From: Chantelle Bashford <Chantelle.Bashford@arun.gov.uk>
Sent: 24 September 2020 14:41
To: Planning.Responses <Planning.Responses@arun.gov.uk>
Subject: RE: Planning Consultation on: BR/131/20/PL

Please see comments from Private Sector Housing below.

Application No: BR/131/20/PL
Registered: 14th July 2020
Site Address: Land between 2b and 4 London Road Bognor Regis NEAR PO2
Grid Reference: 493619 99101
Description of Works: Erection of a commercial unit at ground floor level with residential development of 3 no. bedroom flats above. This application is in CIL Zone 4 (Zero Rated) for flats & shop (Zero Rated).

PROPOSED FLOOR PLANS

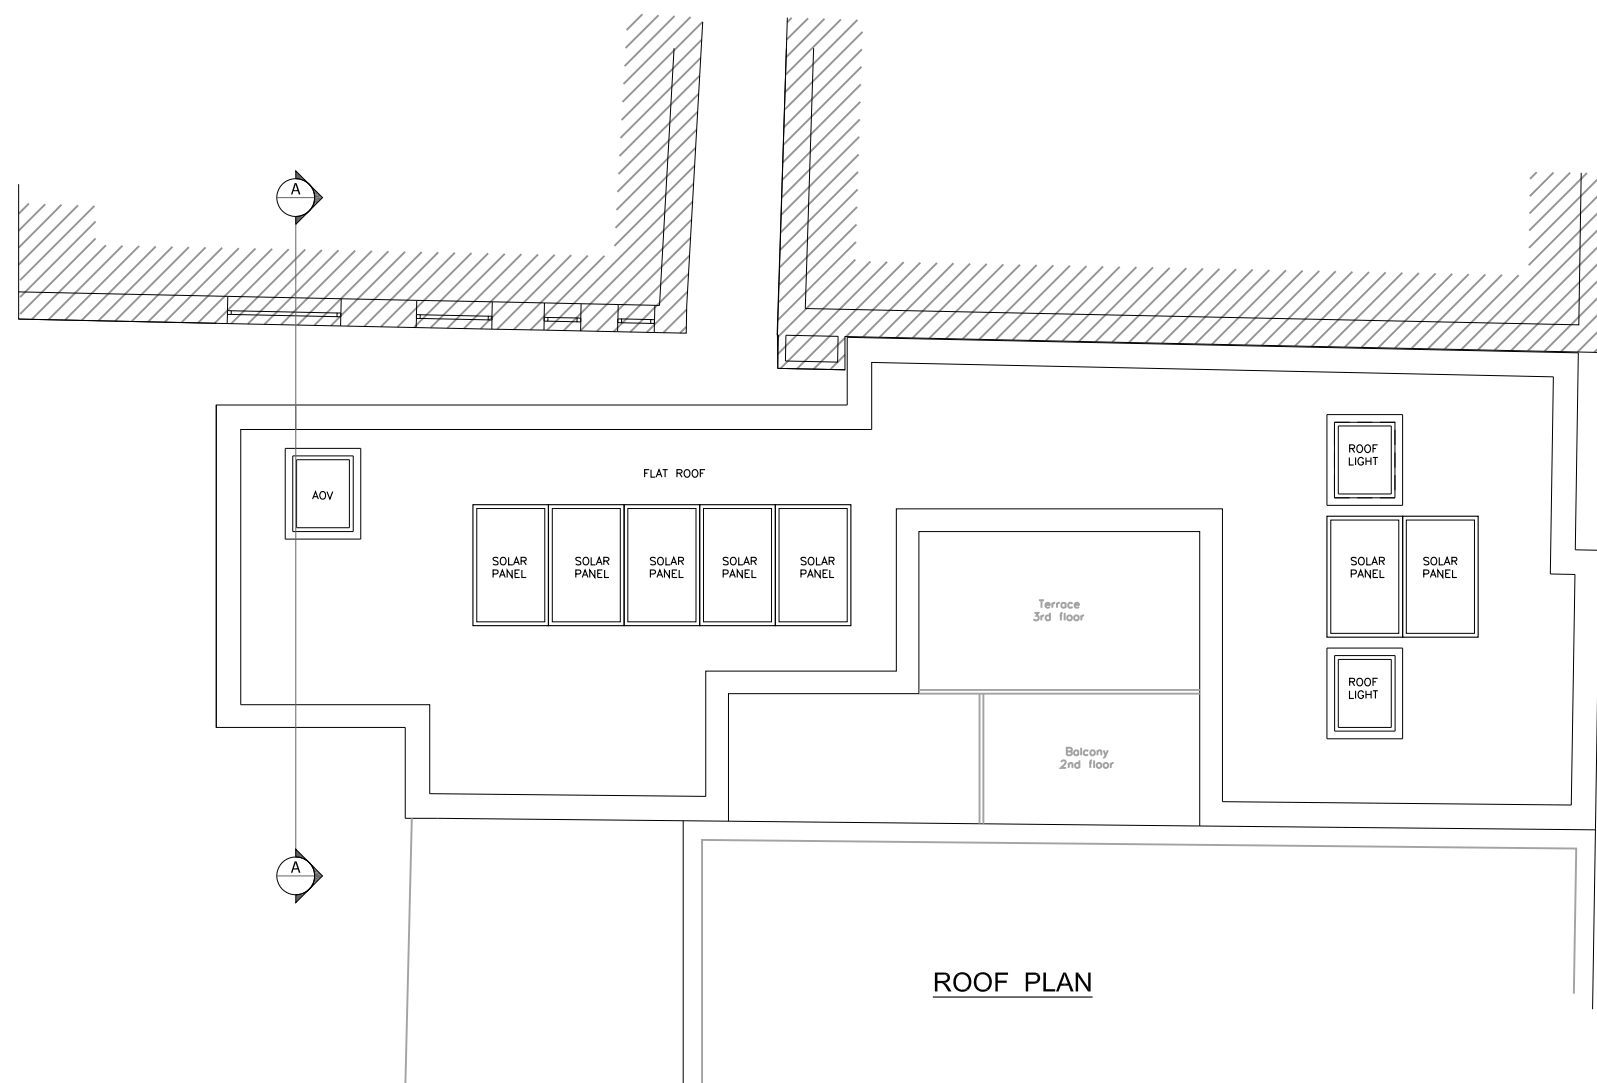
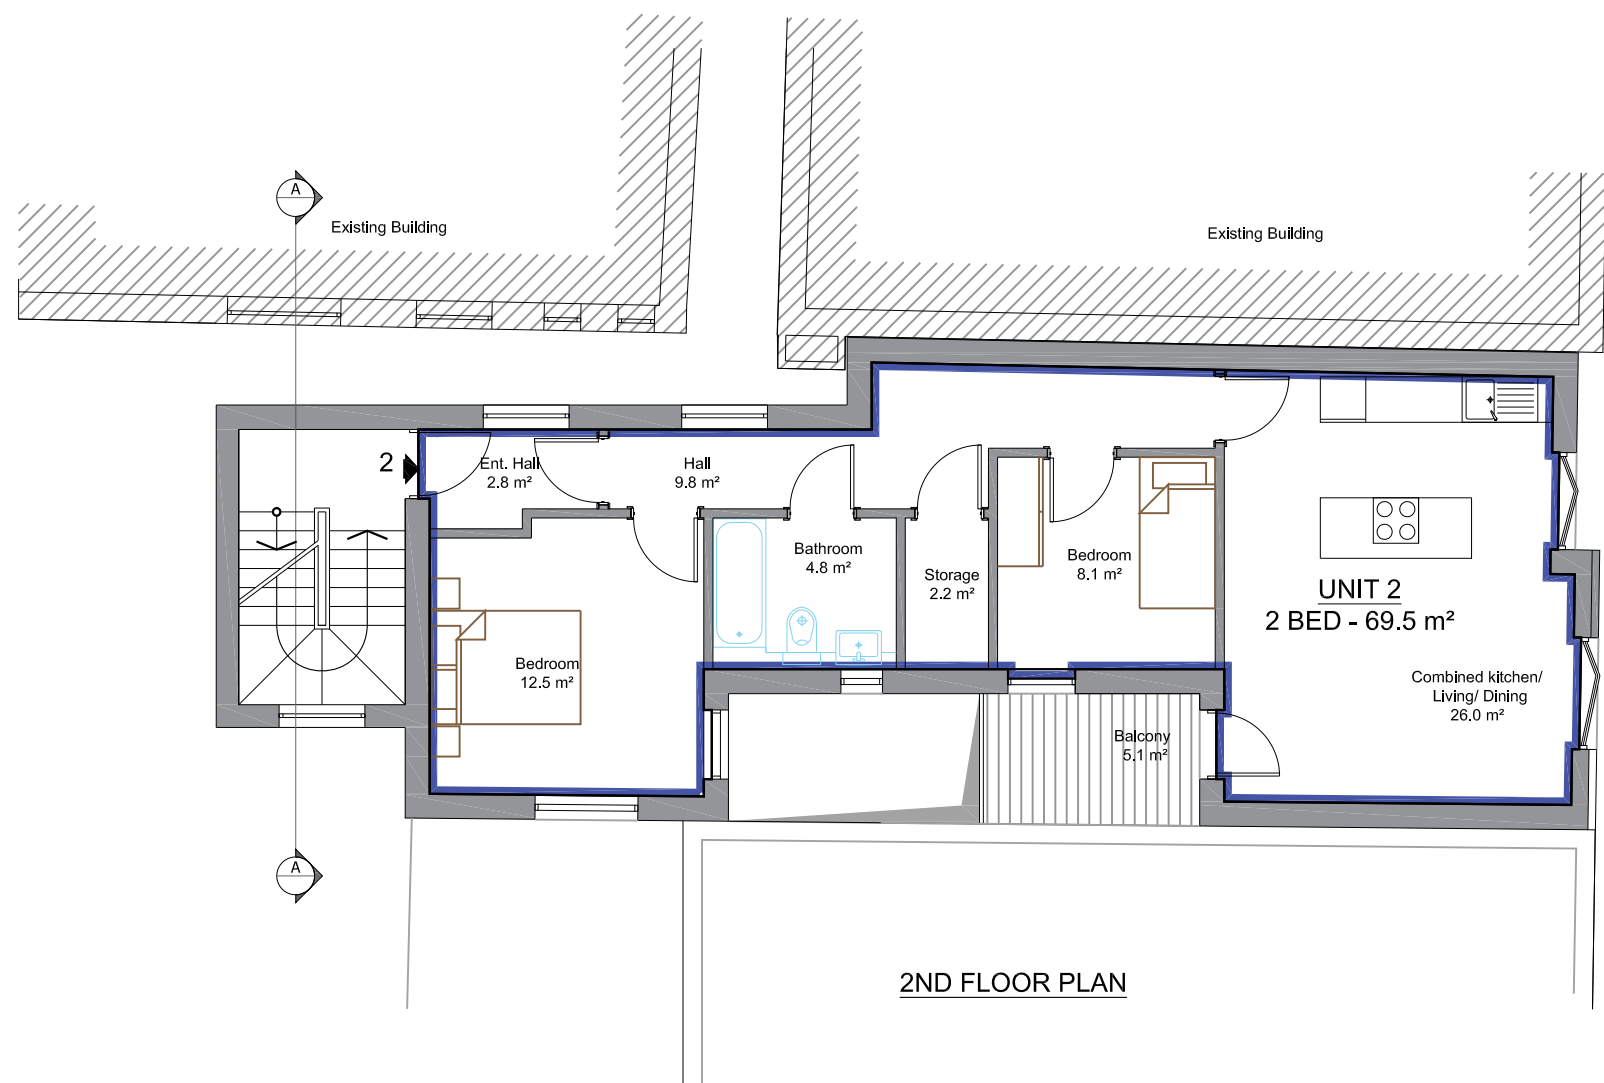
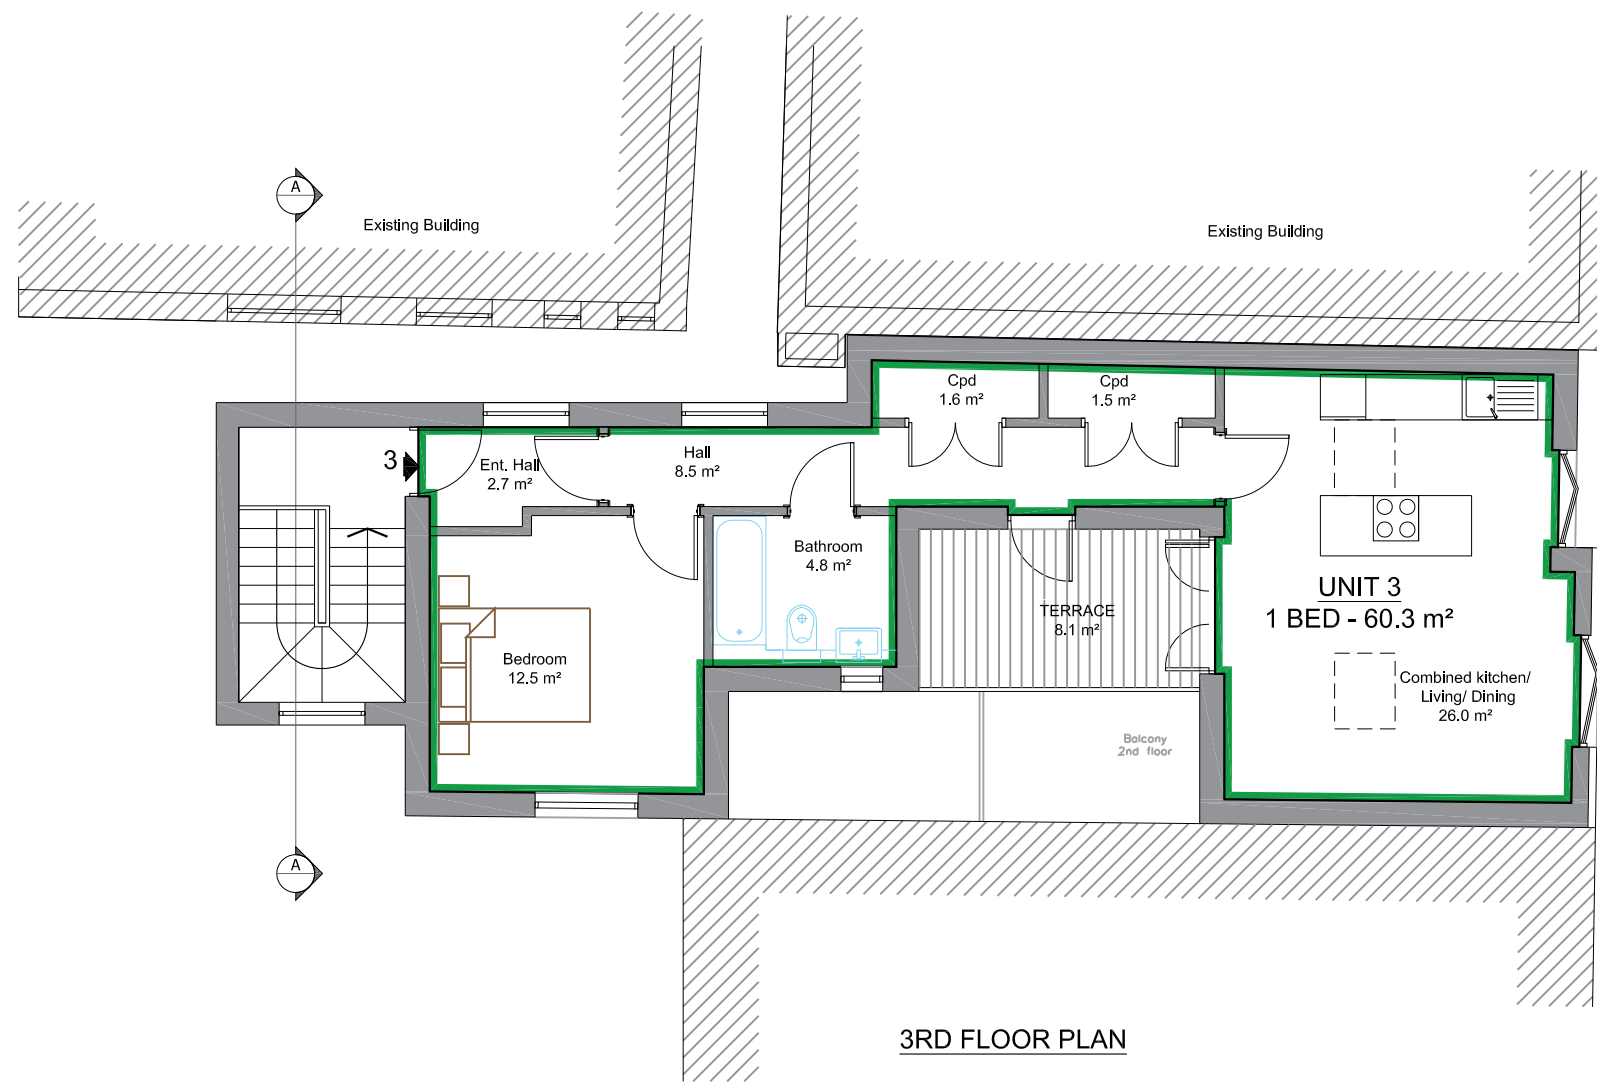
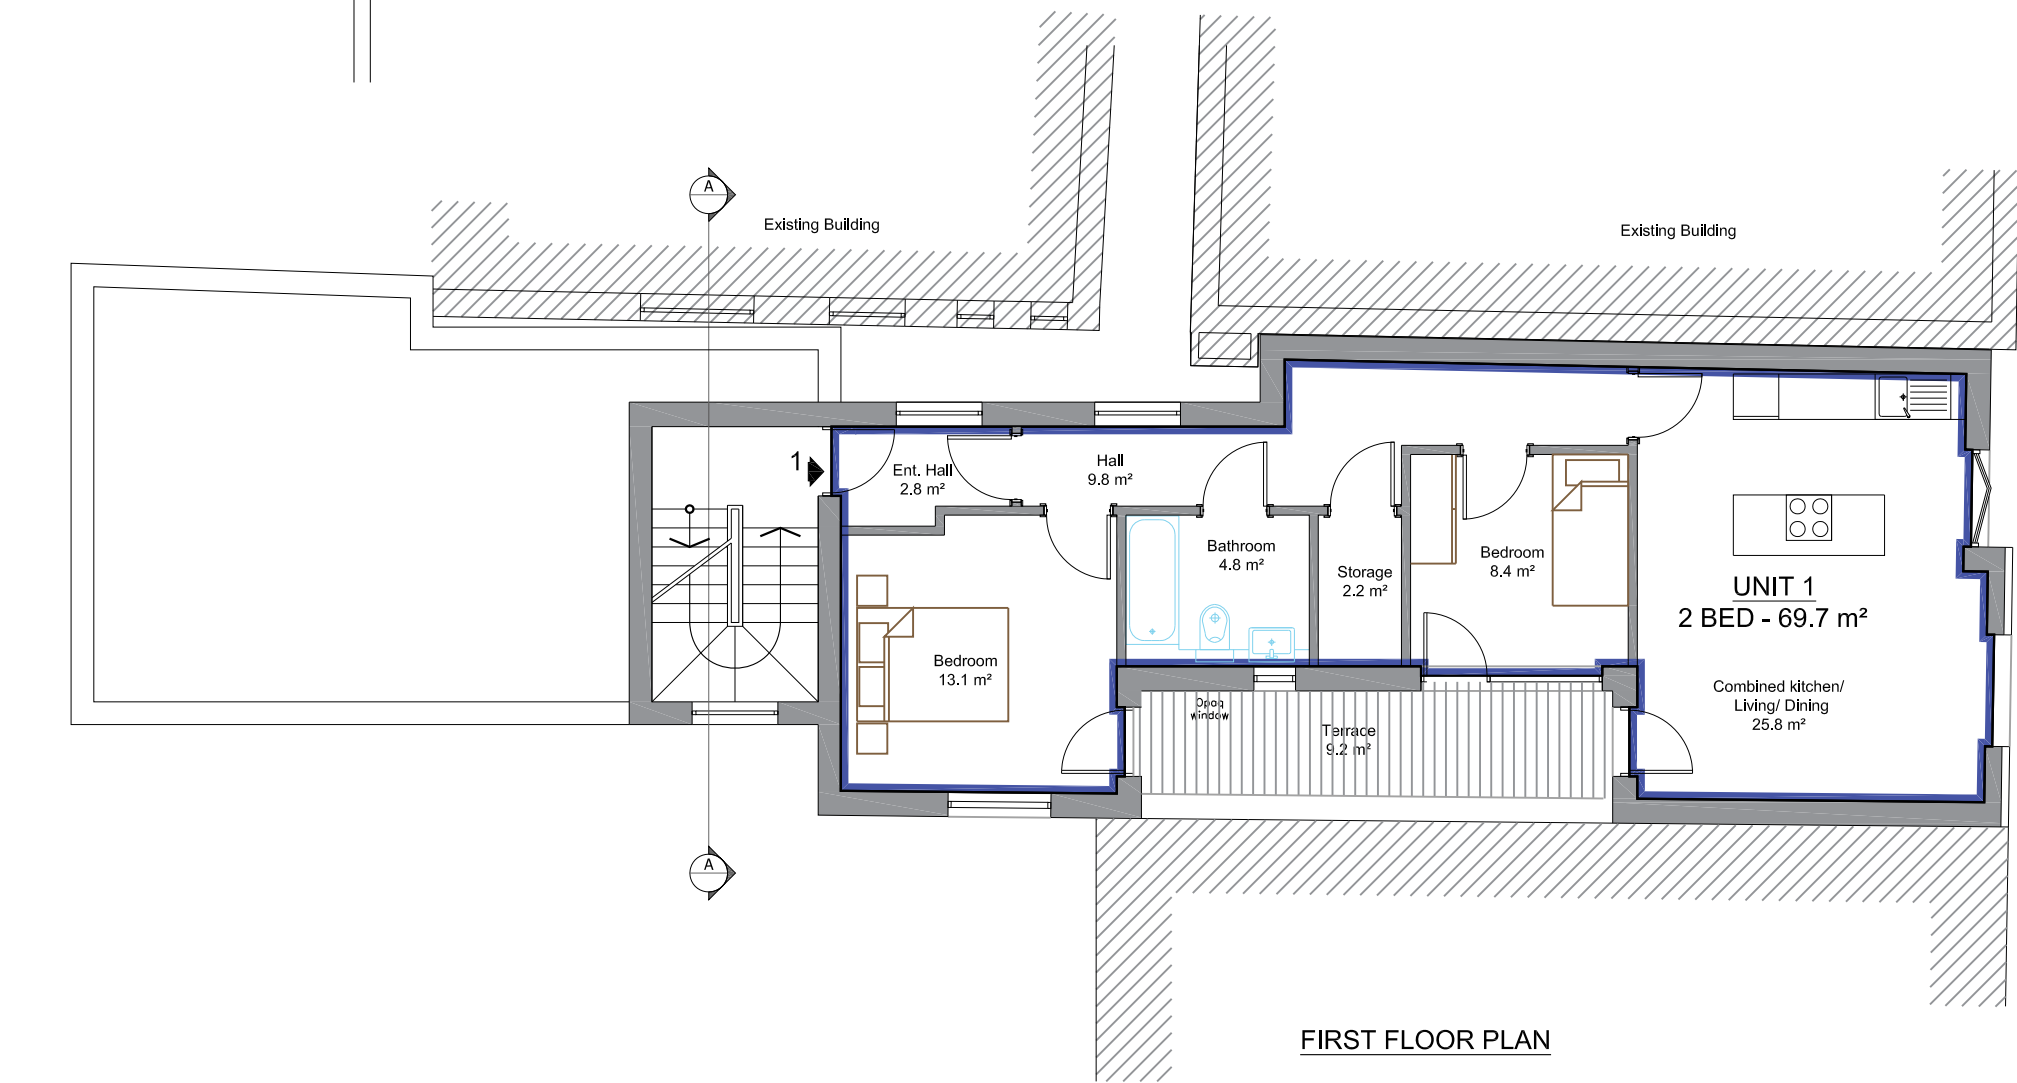
- Appropriate fire precaution facilities and equipment must be provided of such type, number and location as are considered necessary. Guidance on fire safety is contained in the LACORS guidance document – “Housing – Fire Safety, Guidance on fire safety precautions for certain types of existing housing”
- There should be adequate fire separation (usually 60 minutes) between the commercial unit on the ground floor and the residential flats above
- The internal escape route should provide 30 minutes fire resistance, including the provision of 30-minute fire resisting and self-closing fire doors (FD30S) to each flat entrance. If the plant room on the ground floor hallway is housing any electrics/electrical items, FD30S doors will also be required there
- A mixed Grade A, LD2 and Grade D1, LD3 fire system should be maintained and installed

- Interlinked detection throughout the escape route
- Interlinked detection in the commercial unit
- Interlinked detection in the plant room (if any electrics are present)
- Interlinked heat detection to each flat

- Non-interlinked mains-wired smoke alarms with integral tamper-proof battery back-up to each flat

N.B. A Fire Risk Assessment may also recommend interlinked detection is installed within both bin stores

- Fire blankets should be provided to all kitchen areas
- Emergency lighting is likely to be required to the escape route due to borrowed light possibly being limited

- Kitchens should have adequate mechanical ventilation
- Mechanical extraction should be provided to all bathrooms/shower rooms/en suites

- Must meet the requirements of the Housing Act 2004 and be free of Category 1 and significant Category 2 Hazards
- Units 1 & 2 have the potential to operate as a House/Flat in Multiple Occupation (HMO), depending how they are occupied. If either flat becomes an HMO, it must;
- Meet the requirements of the Arun District Council Houses in Multiple Occupation Standards (2020)
- Meet the requirements of The Management of Houses in Multiple Occupation (England) Regulations 2006
- Meet the requirements of any other associated Housing and/or Houses in Multiple Occupation legislation or regulations if applicable to the property/site

- It is noted there are two fire exits and a door leading from three surrounding buildings into the communal hallway on the ground floor, presumably providing an escape route from these neighbouring properties. Having an escape route lead into another building is not ideal and poses a number of potential issues such as the exits being blocked by tenants' belongings. It would be advisable to communicate with the owner(s) of these three buildings to discuss the escape routes and perhaps even to get a legal agreement put in place. Additionally, the Fire Risk Assessments for the three surrounding buildings may not deem the escape routes suitable if they have to pass through a neighbouring building.
